**ADC Planning Consultation
Response from the Conservation Officer**

Application Number	WA/21/14
Address	Turnpike Motors, The Street, Walberton
Description	Demolition of garage and workshops and erection of 6 No 3 bed dwellings, alterations to access, parking and incidental sheds for cycle storage. This application affects the character and appearance of the Walberton Village Conservation Area.
Case Officer	Mrs. A Gardner

**Proposed site plan and
Street Elevation**

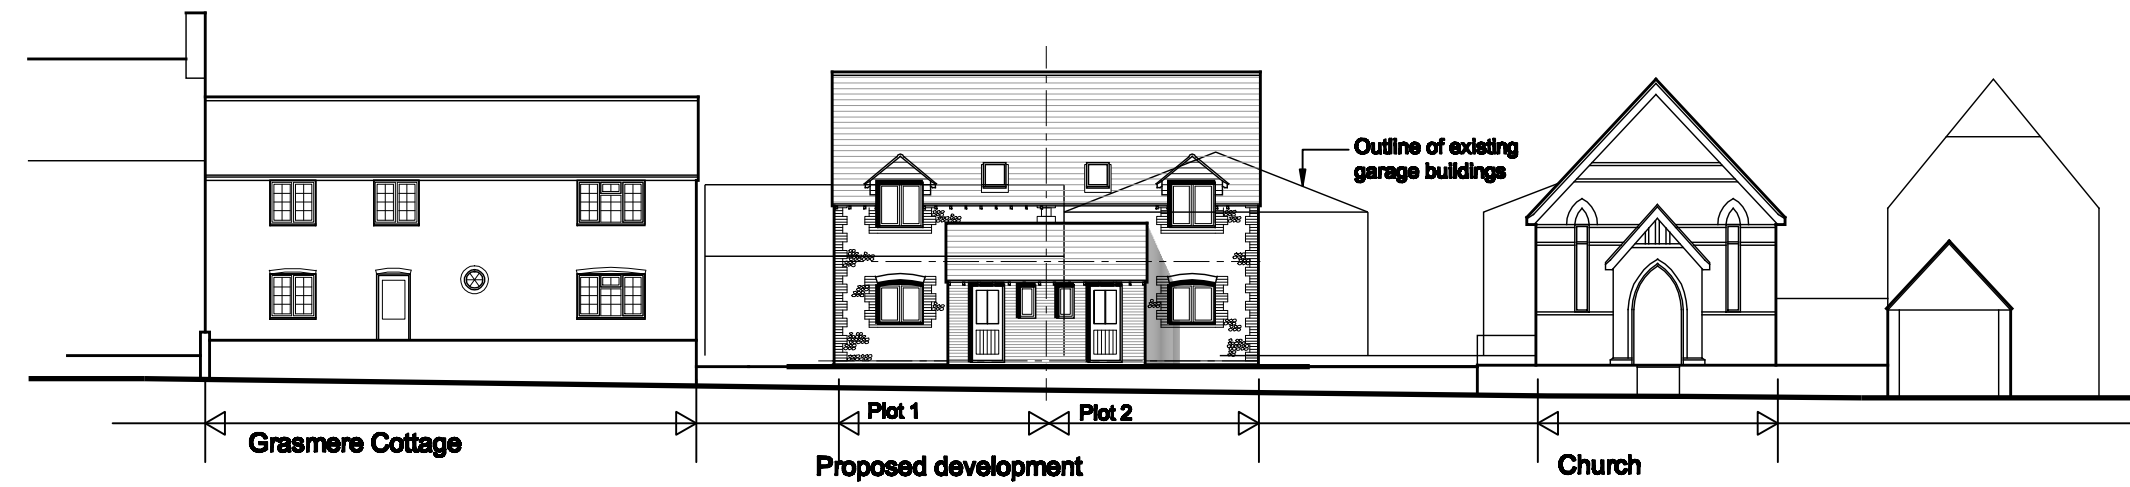
With regards to the layout of the scheme, it appears to have been designed to maximize the sites financial potential. However, it is considered this it is problematic. The proposed layout results in the creation of a courtyard area which appears to be more of a car park than a usable space or attractive alcove within the conservation area. The focus on the car and the provision of hard-standing, leaves small pockets of land (planting/grass?) with no real identity or purpose; who will use or take ownership? No clear information appears to have been provided regarding landscaping.

Boundary treatment to plots 1 and 2 enhances the car park feel of the courtyard. Ultimately, it creates an area which is hard-scaped focused.

Site ownership surrounds the Baptist church on the eastern and southern sides. It is now clear how this will be demarked

In addition, it is not clear how the neighbouring flint barn structure will be treated.

Rev A Roof lights shown on first floor plan and roof plan			April 2014
REVISION			
PROJECT		Proposed development at Turnpike Motors, The Street, Walberton	
SUBJECT		Proposed Cottage Floor Plans and Elevations	
SCALE 1:100 @ A2	DATE April 2014	DRAWING No 02 / 62 / 08	Rev A
DRAWN	CHECKED

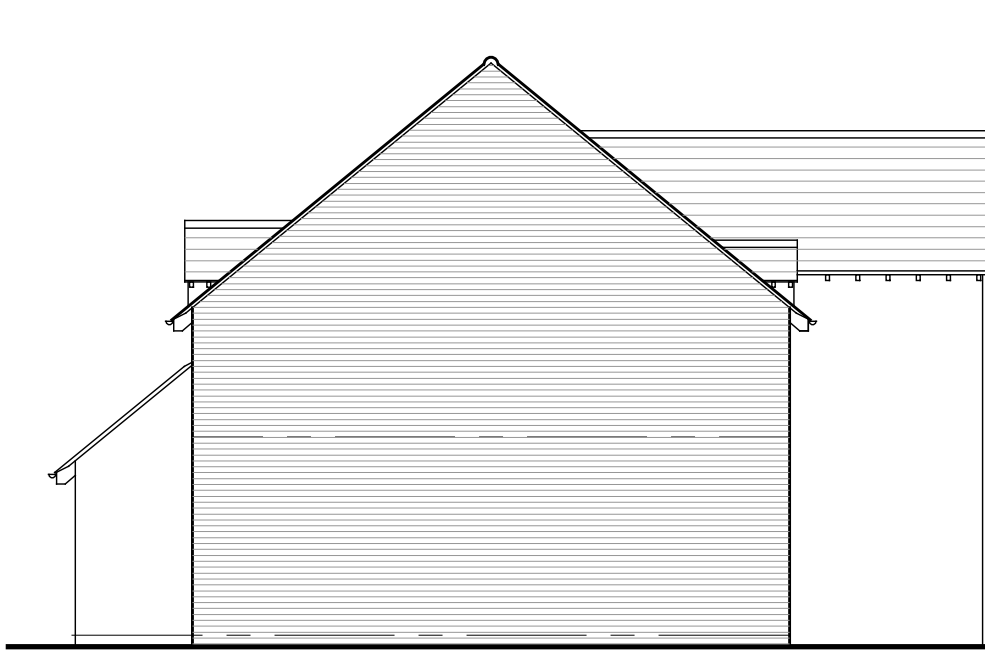
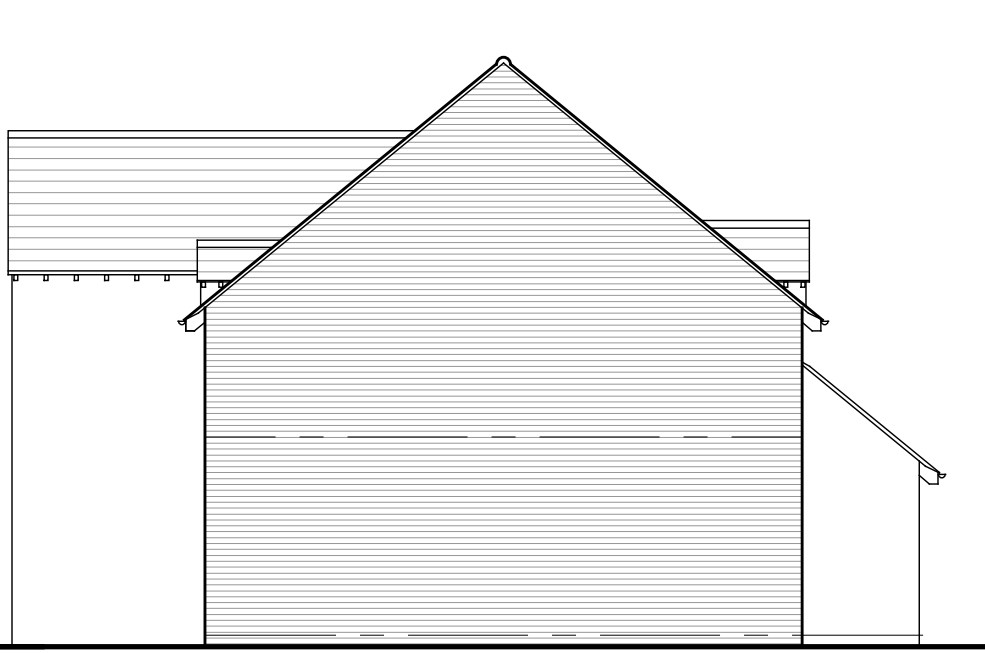
Properties on the southern side of the street are mostly two stories, attractive with either, no or very discrete porches. Whereas, the proposed properties have porches which are large, with roofs that dominate the front elevation.

This is enhanced through the provision of dormer windows; another feature not present in the local street-scene.

In addition, as a point of detail, the roof-lights should be of conservation standard.

The introduction of the porch and the dormers etc. are therefore considered to be in conflict to the surrounding properties and harmful to the street-scene.

It is therefore considered that a fresh approach is required; the properties should be simple, with high quality detailing reflective of other properties within the local area.
